**Re: Allsup's Convenience Store #102460 at 9501 Gibson Blvd. SW
Erosion and Sediment Control Plan
Engineer's Stamp Date – 6/2/2023 (M09E034)**

Based upon the information provided in your submittal received 7/17/2023, the above referenced ESC Plan cannot be approved until the following comments have been addressed.

Principal Engineer, Planning Dept.
Development and Review Services

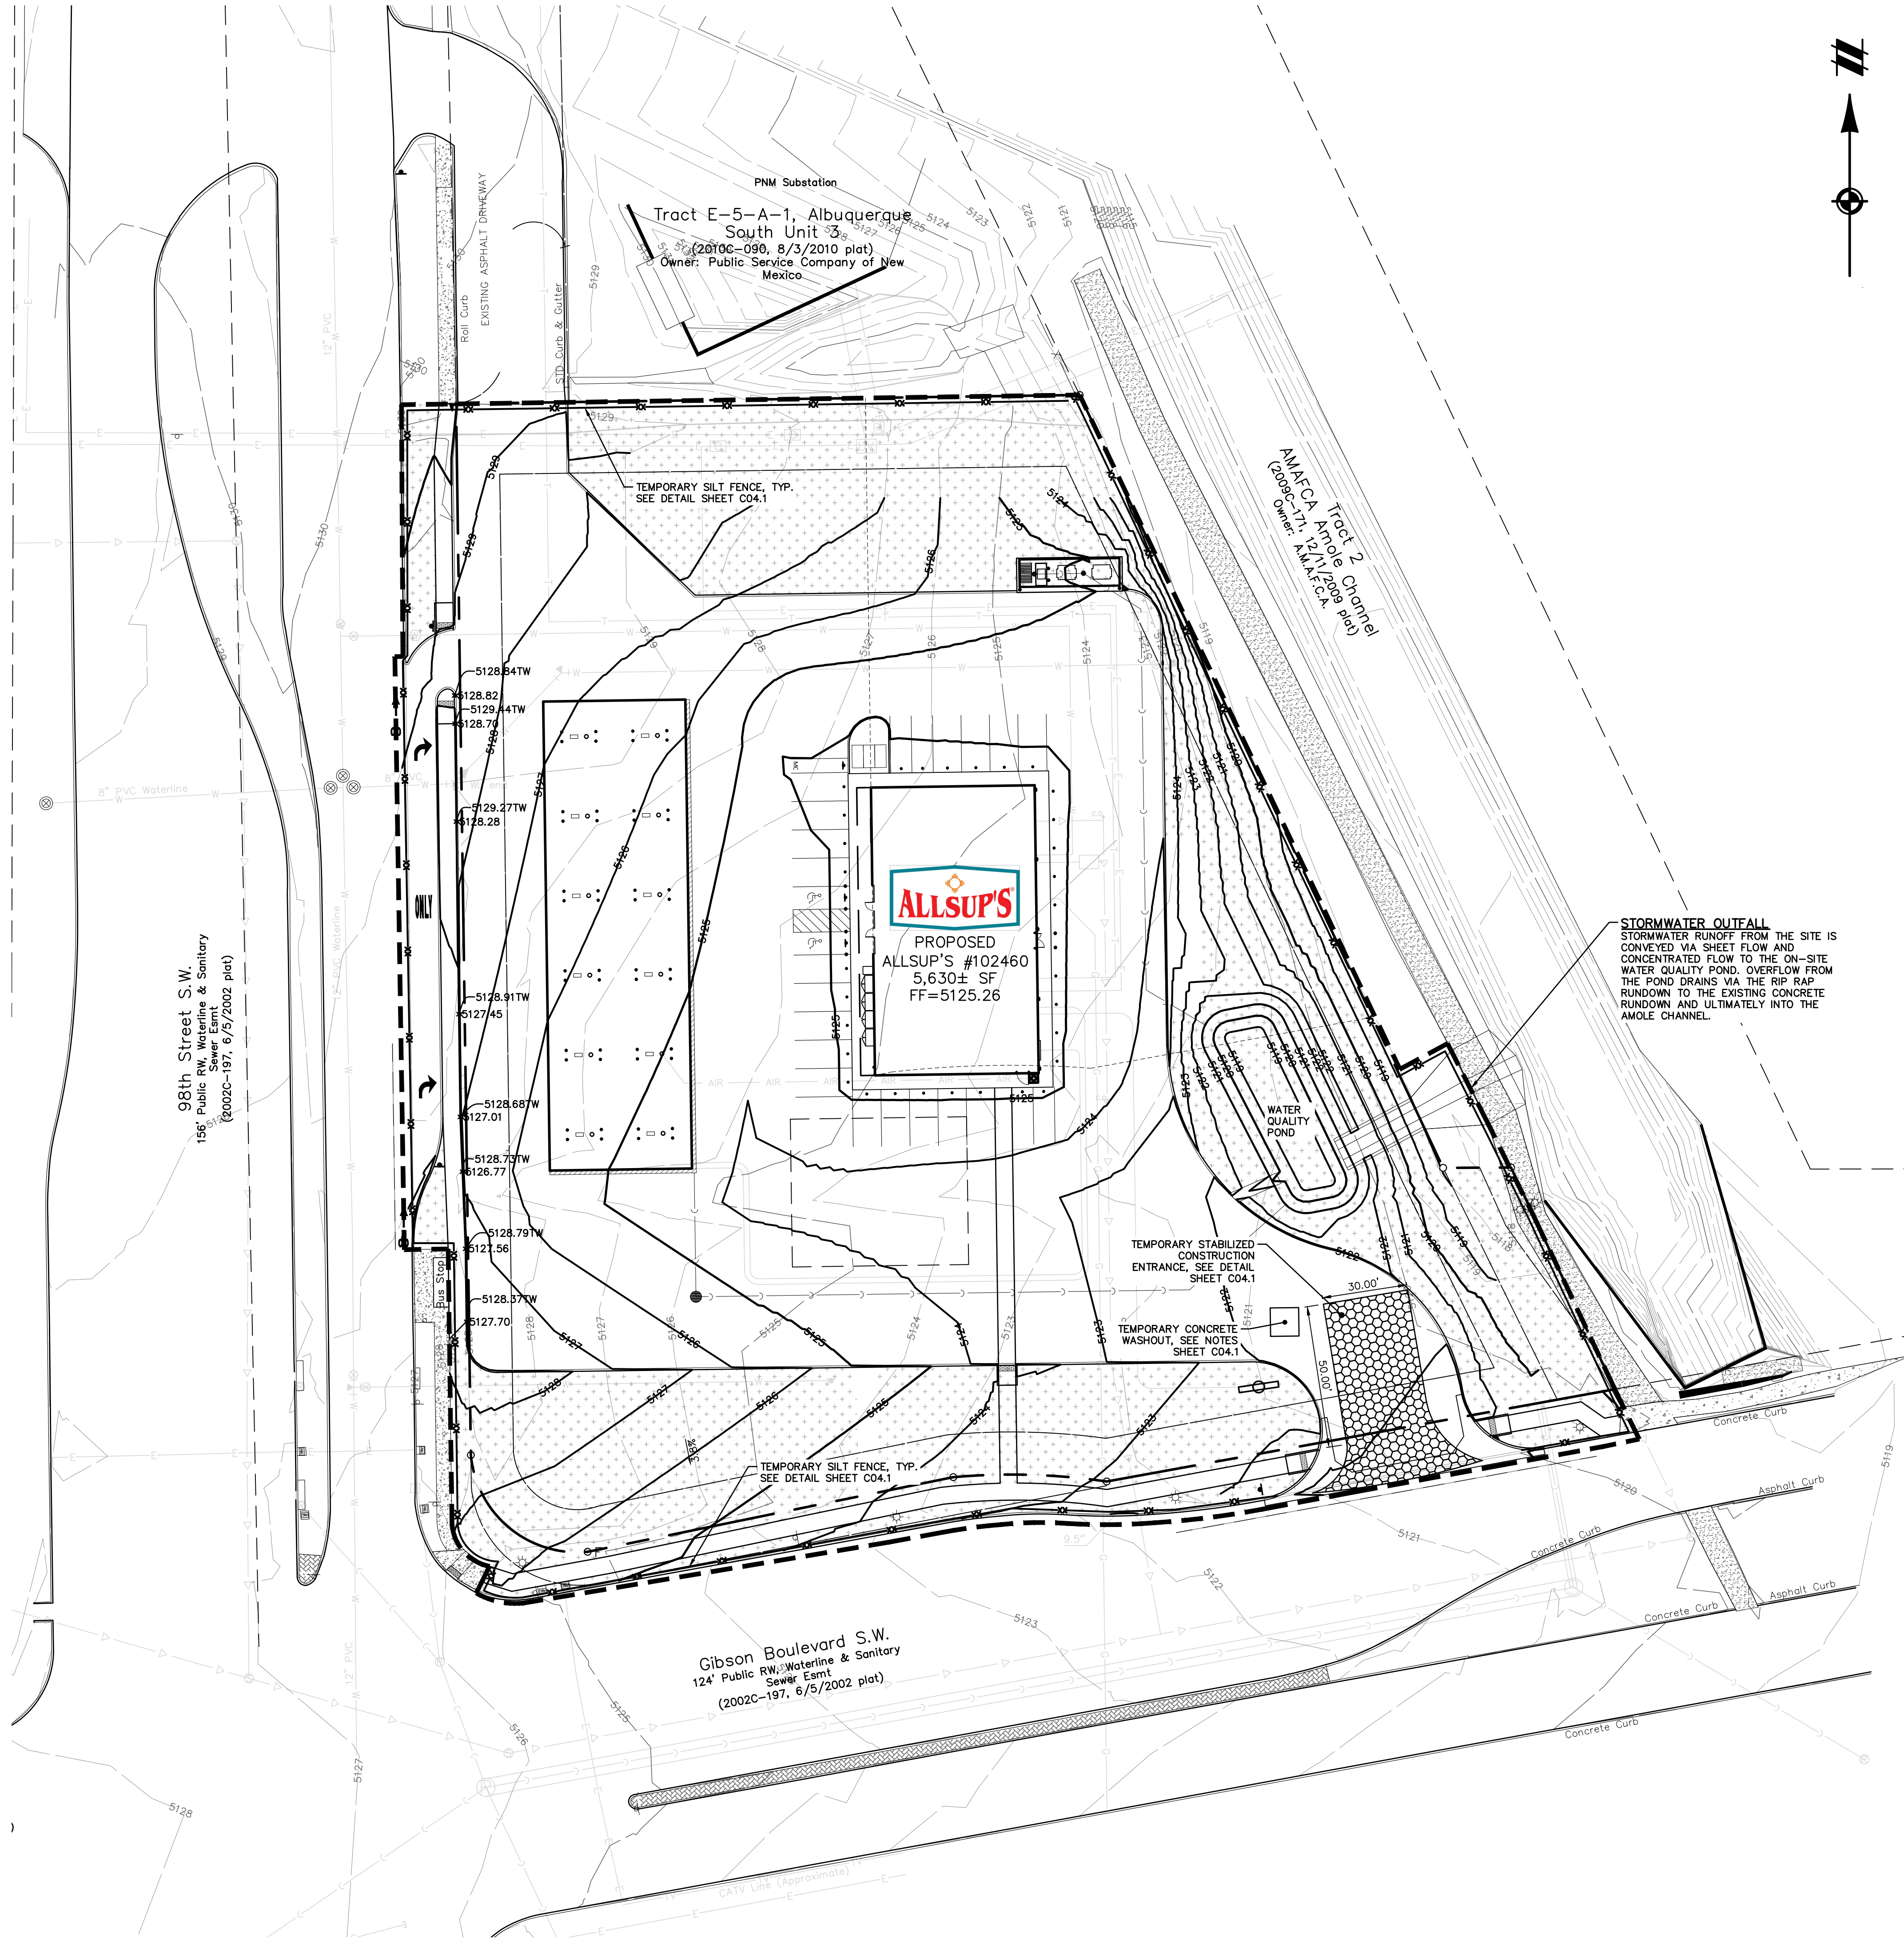
1. This plan shows a big hole in the silt fence at the low corner where you have located the construction exit contrary to CGP 2.2.3 and contrary to standard Erosion and Sediment Control (ESC) practices. You must revise the design of your BMP controls to insure that stormwater runoff is ponded before it leaves the site in accordance with CGP 2.2.3. At a minimum provide continuous silt fence across the low corner with no holes. Consider adding a properly sized temporary sediment trap there also. The construction exit should be located at the high corner of the site, the northwest corner, at the end of the existing asphalt driveway.

3. Identify locations of concentrated flow paths that enter and exit the disturbed areas. Identify locations where sheet flow enters and exits the disturbed area. Show on-site drainage patterns of stormwater before and after major grading activities. (CGP 7.2.4.f)
